From: Moor Construction LTD GMAIL [REDACTED]
Sent: 23 August 2021 10:53
To: Nicola Moore
Subject: AB/102/21/DOC
Attachments: 200042_104_proposedfloorplans-A1 SHEET.pdf

In response to the letter dated 18th August 2021 from Neil Crowther, regarding skirting and architrave we propose to use the same as already in place, please see the links for this.

Project:-	Old Bank House 1 High Street Arundel West Sussex		
Title:-	Proposed Floor Plans		
Client:-	Moor Construction Ltd		
Scale:-	1:50 (@A1)		
Drawn By:-	PJD	Checked By:-	
Date:-	12/02/21	Date:-	
Job.No:-	200042	Drg.No:-	104

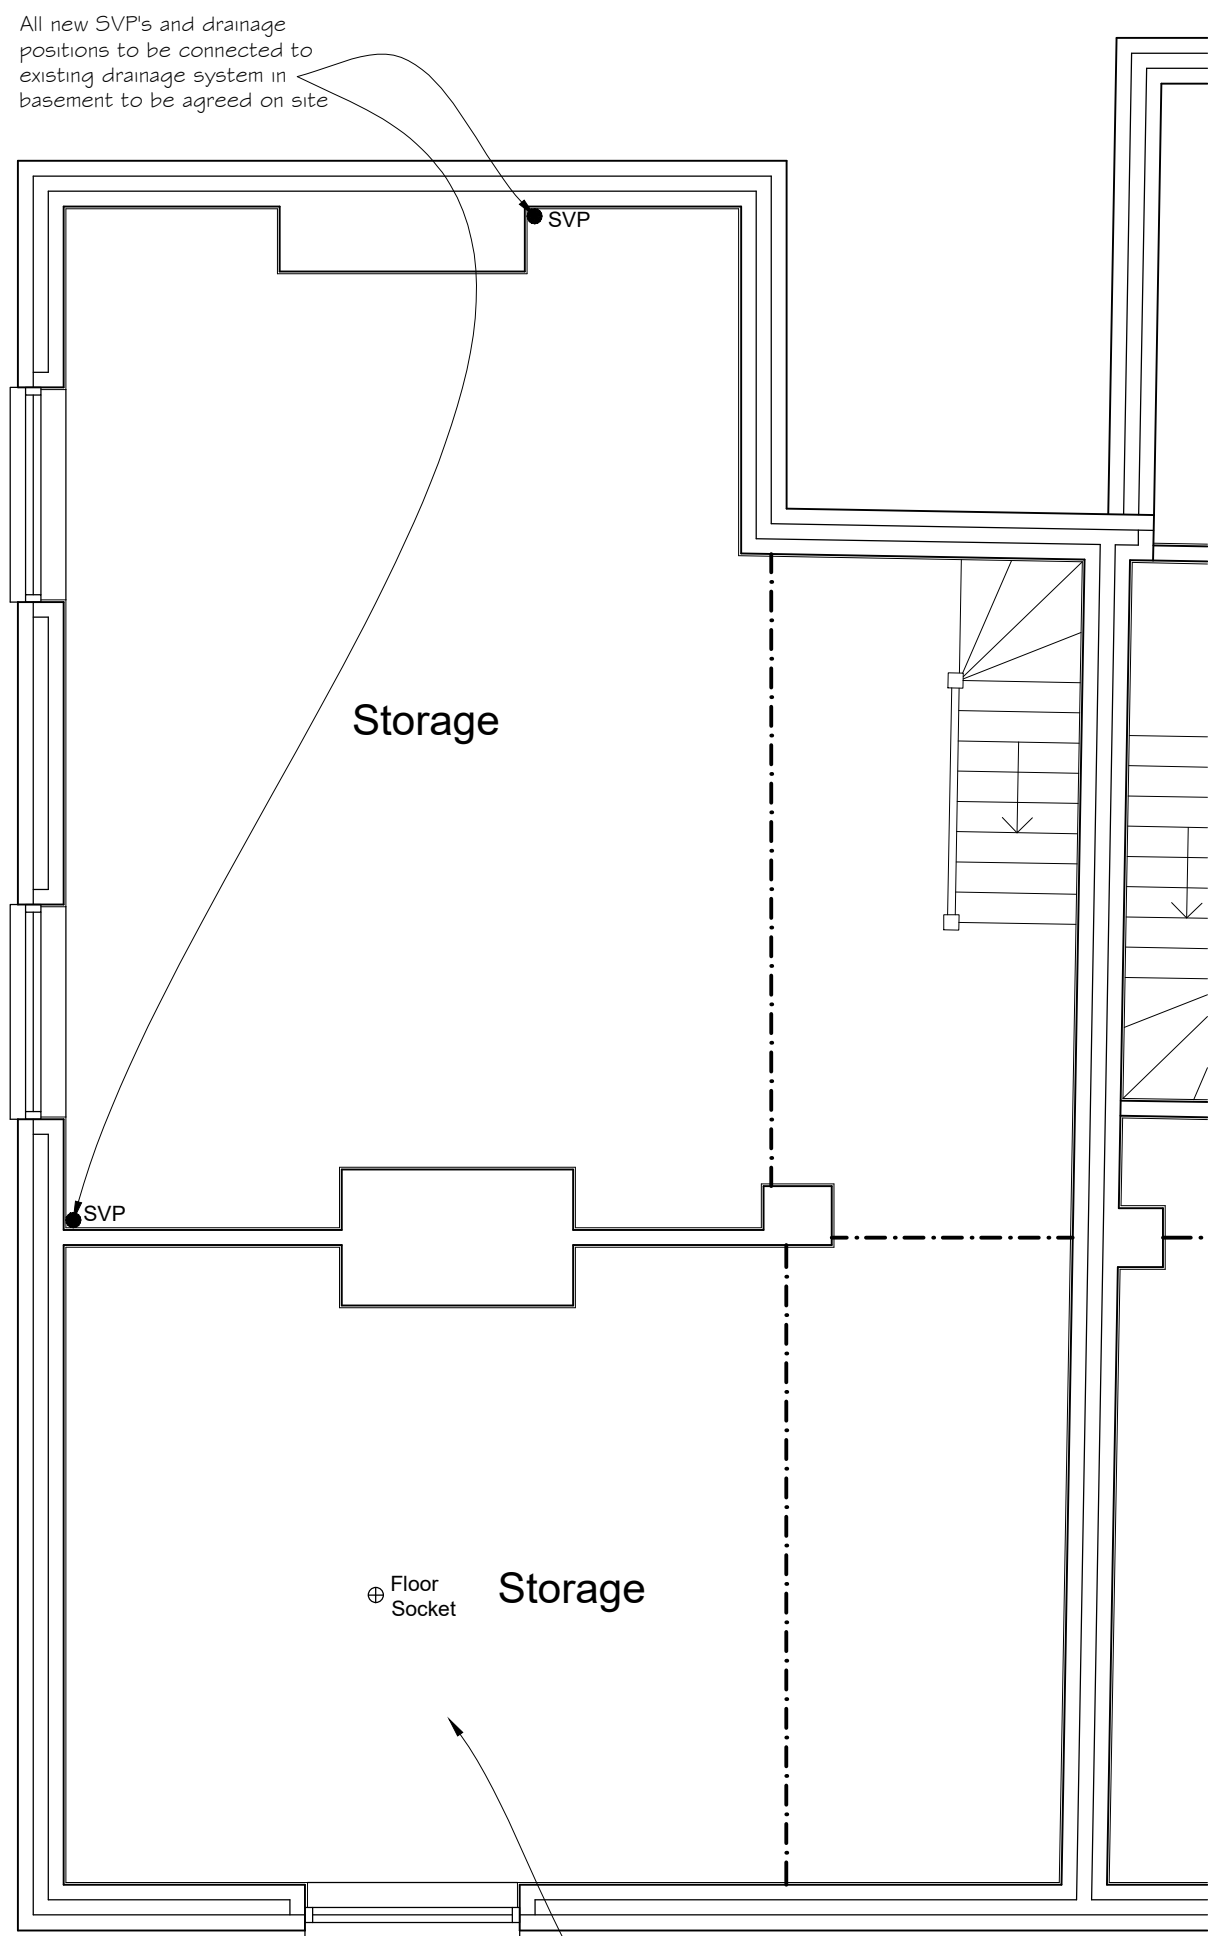
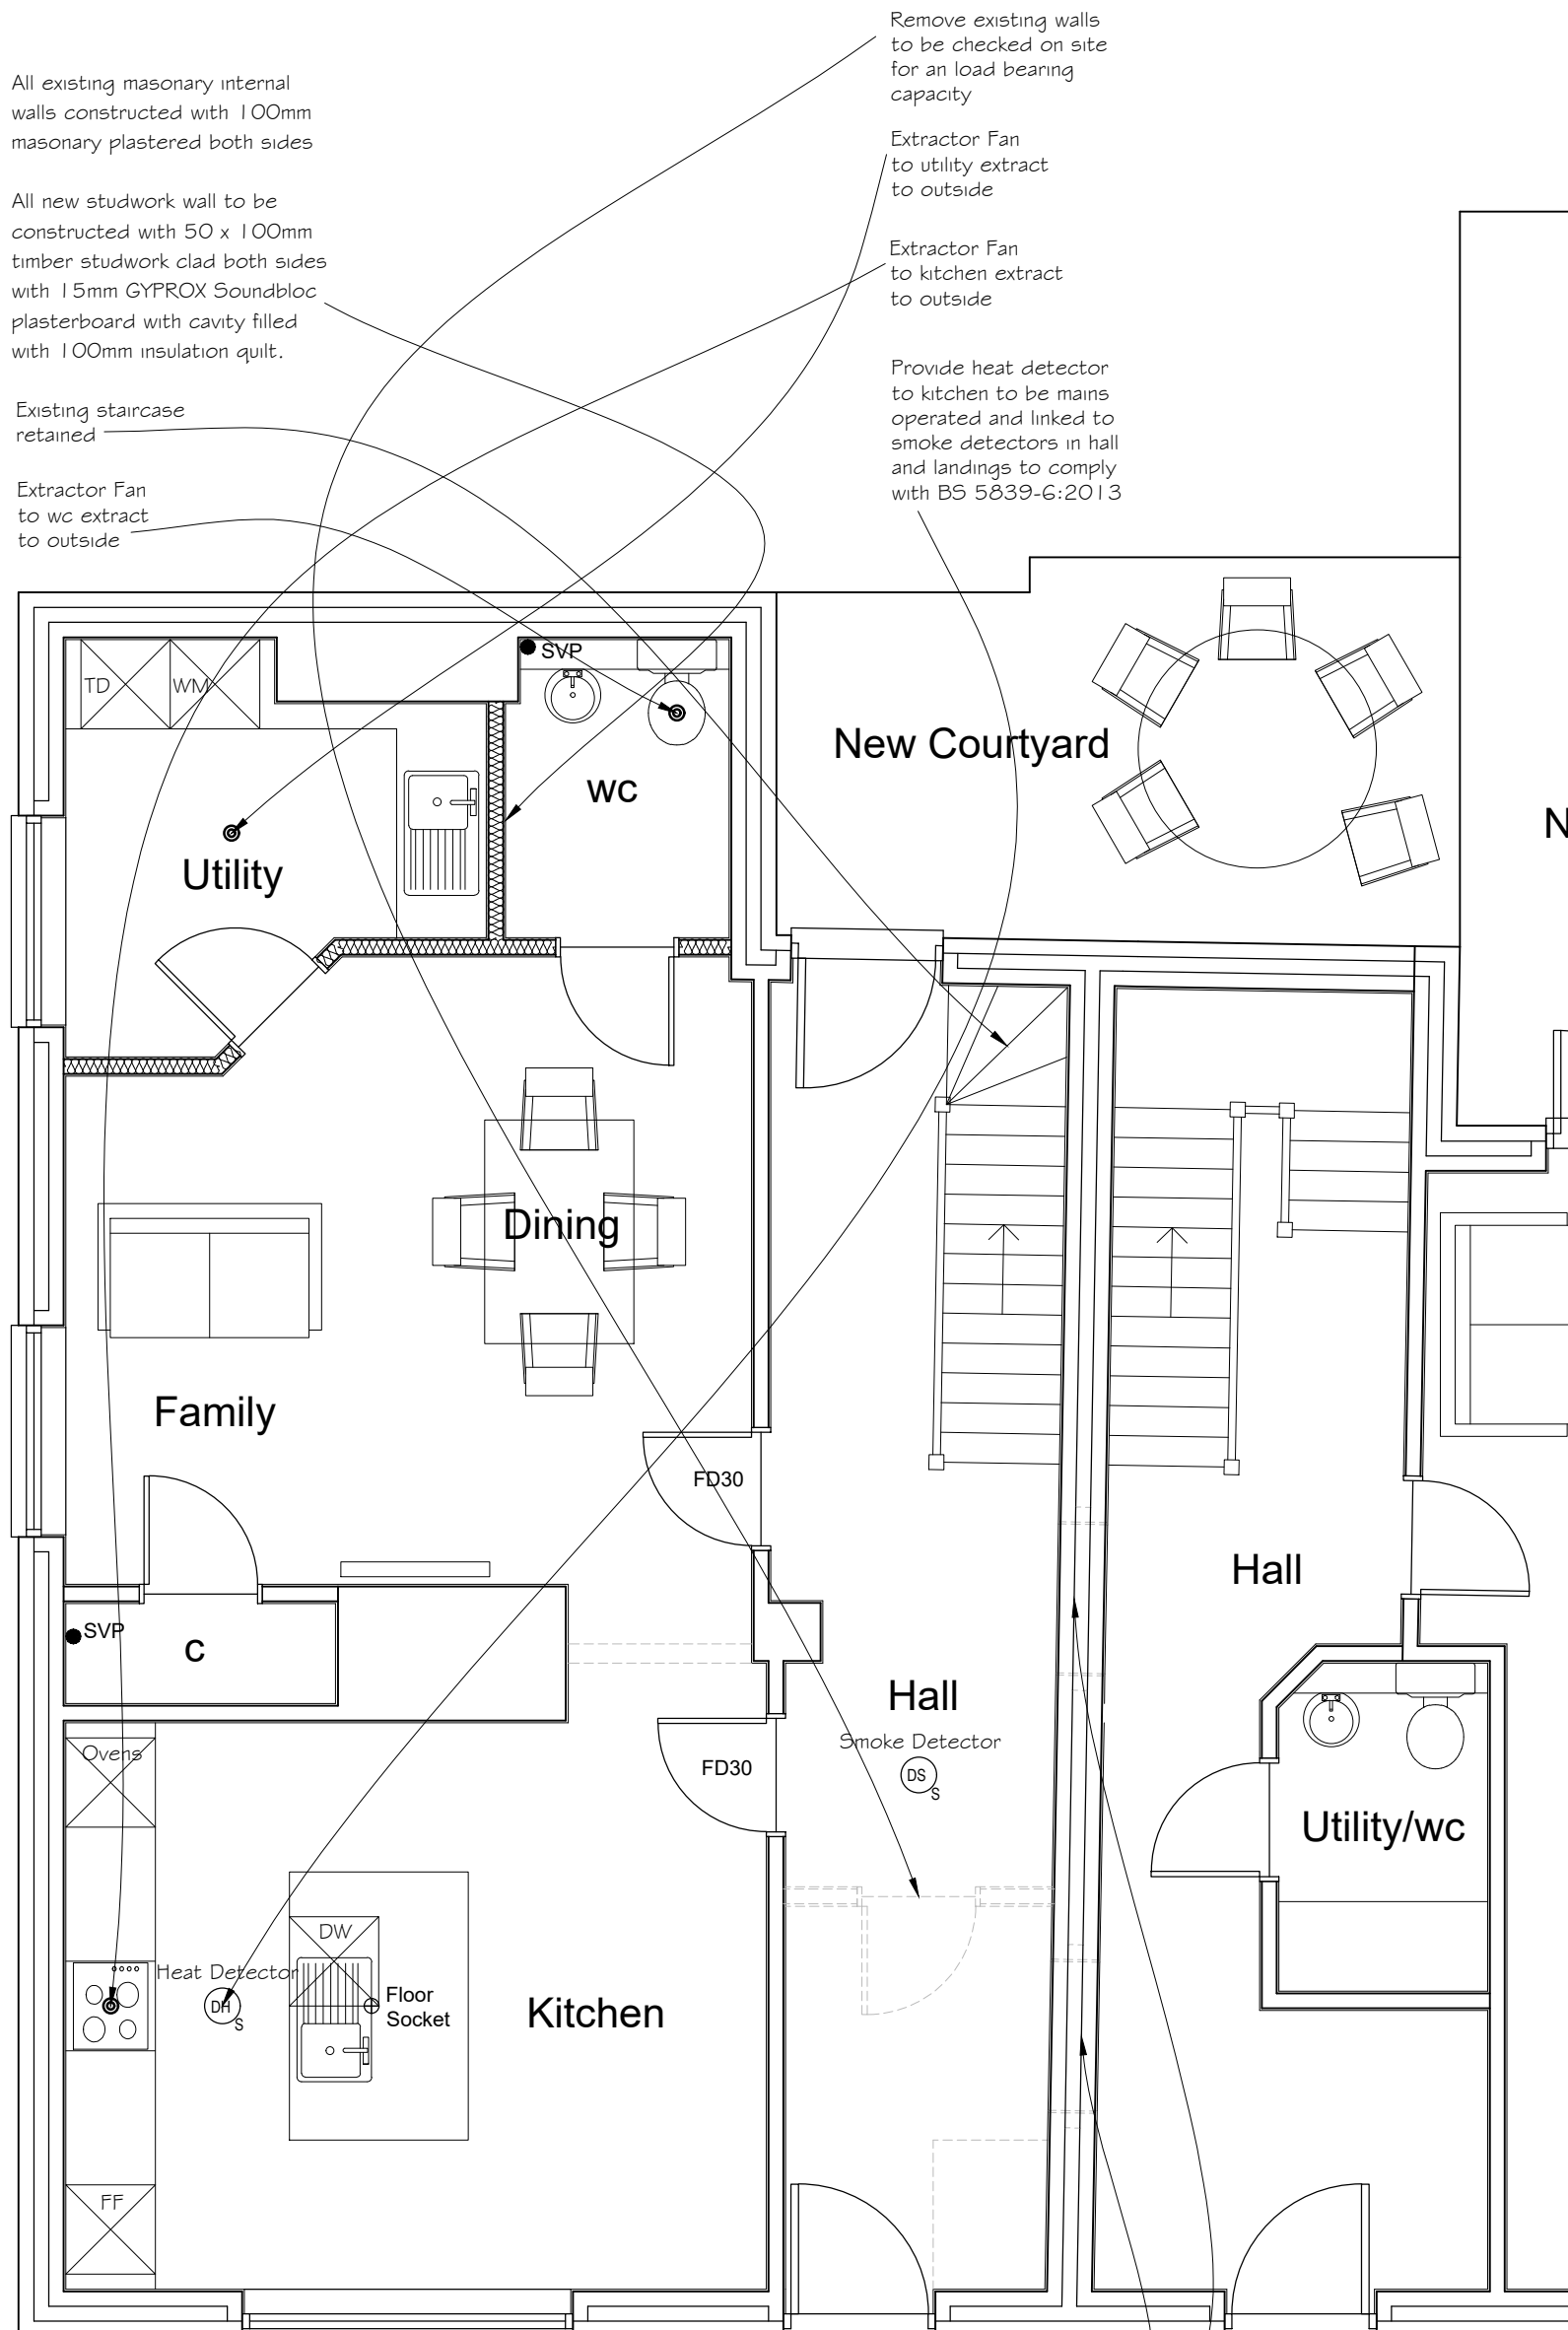
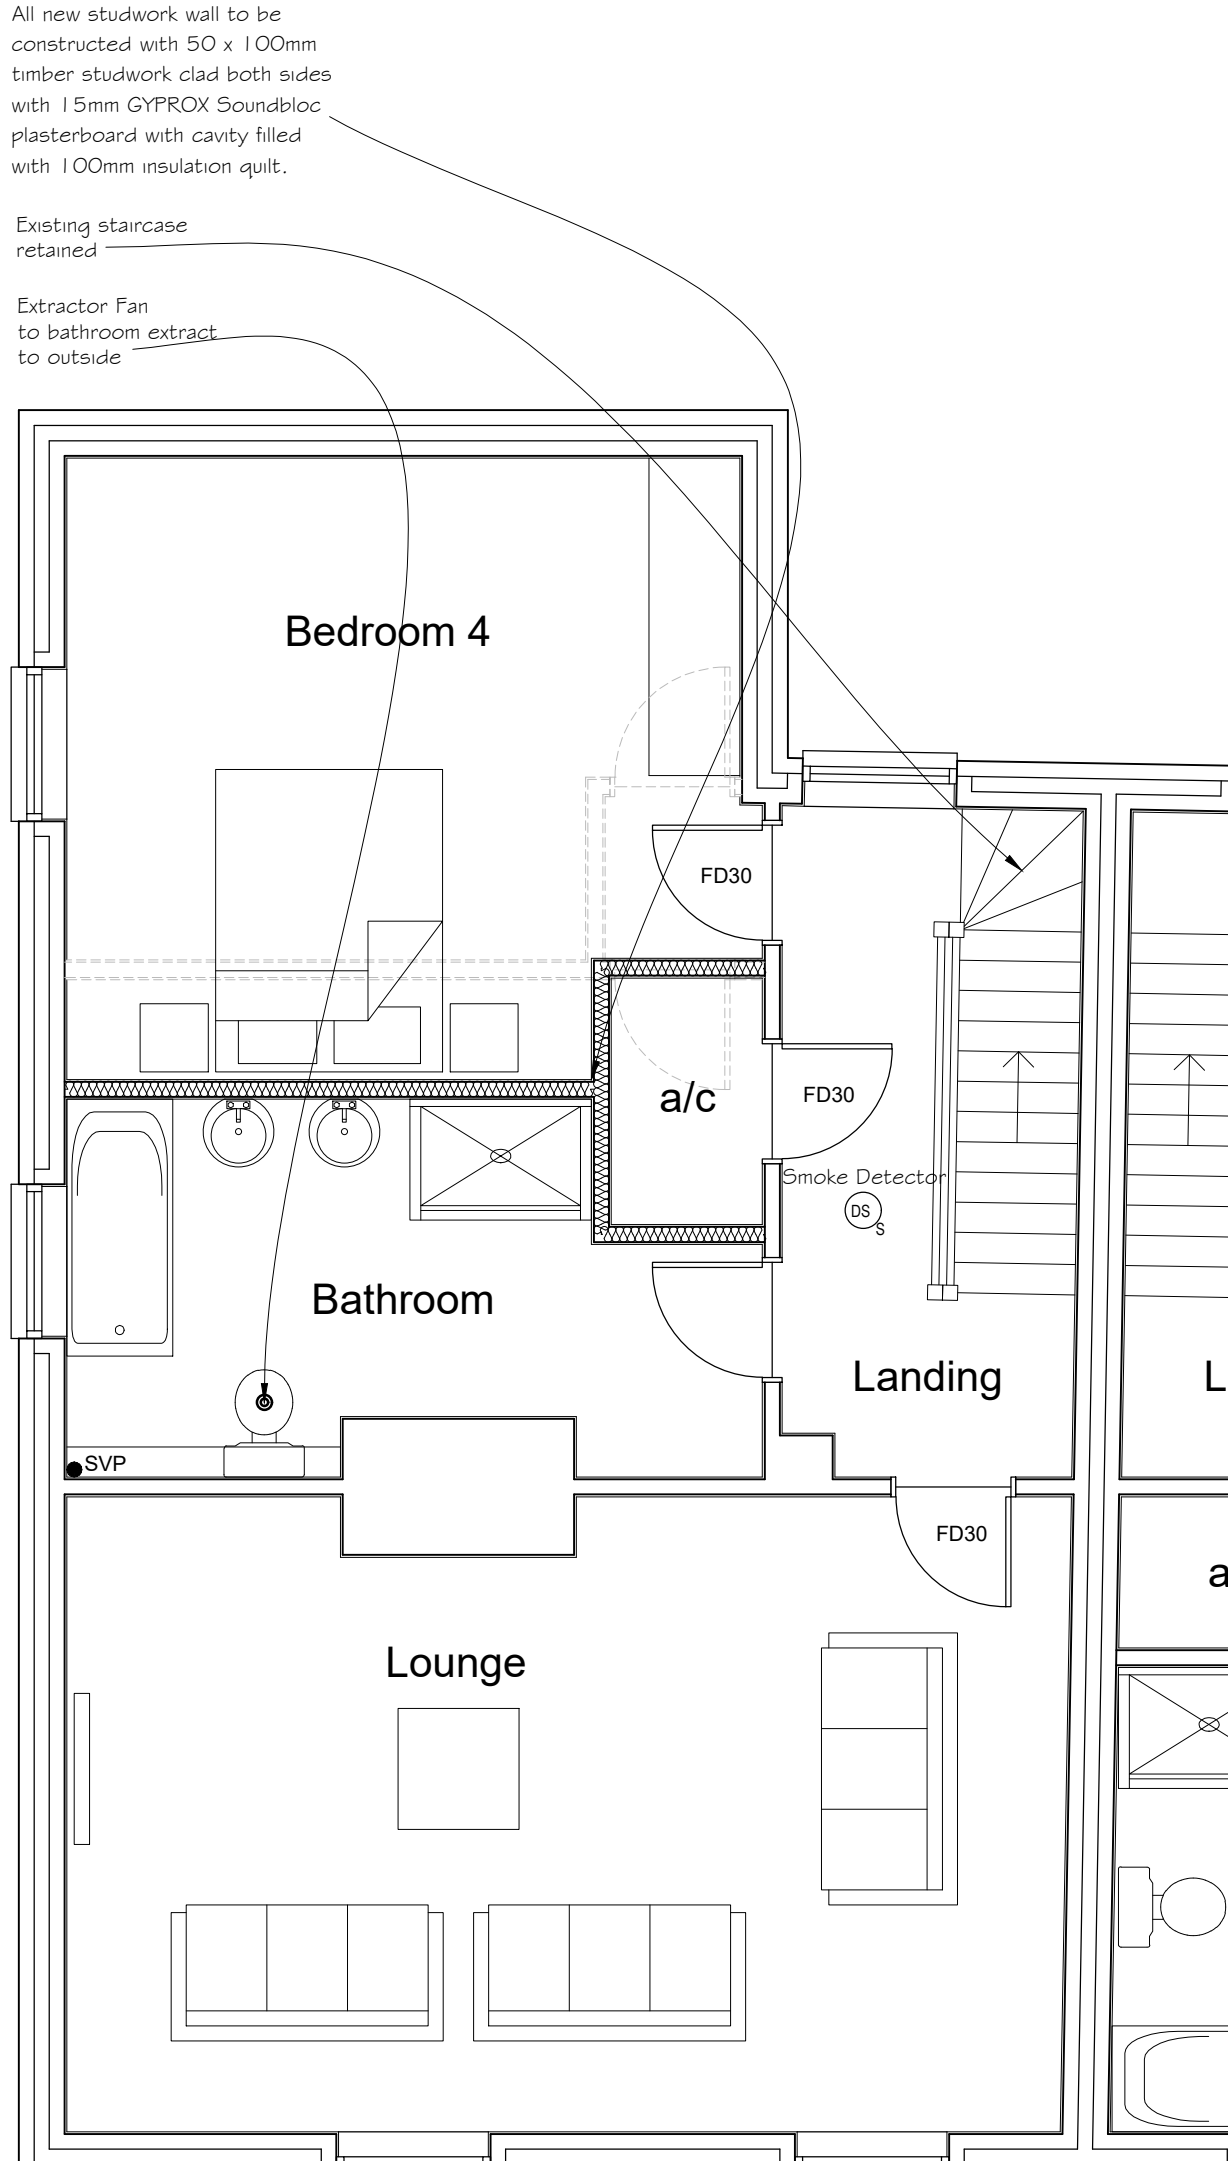
Reference the draining and electrical in bathrooms and kitchens:

The drainage is as per the drawings (see attached) and is boxed in so there is nothing visible, this goes into the basement of the property so there will be no external works for drainage.

Electrical system, I can only assume that you are referring to the extraction. Again this is totally boxed in within the building so nothing is visible.

On the outside the kitchen extraction will be behind an existing air vent at the front of the property.

For the bathrooms, externally they will exit through a grill already in place so no works.

Low level, the kitchen and utility room will exit into the courtyard which will not be visible other than a small grill.
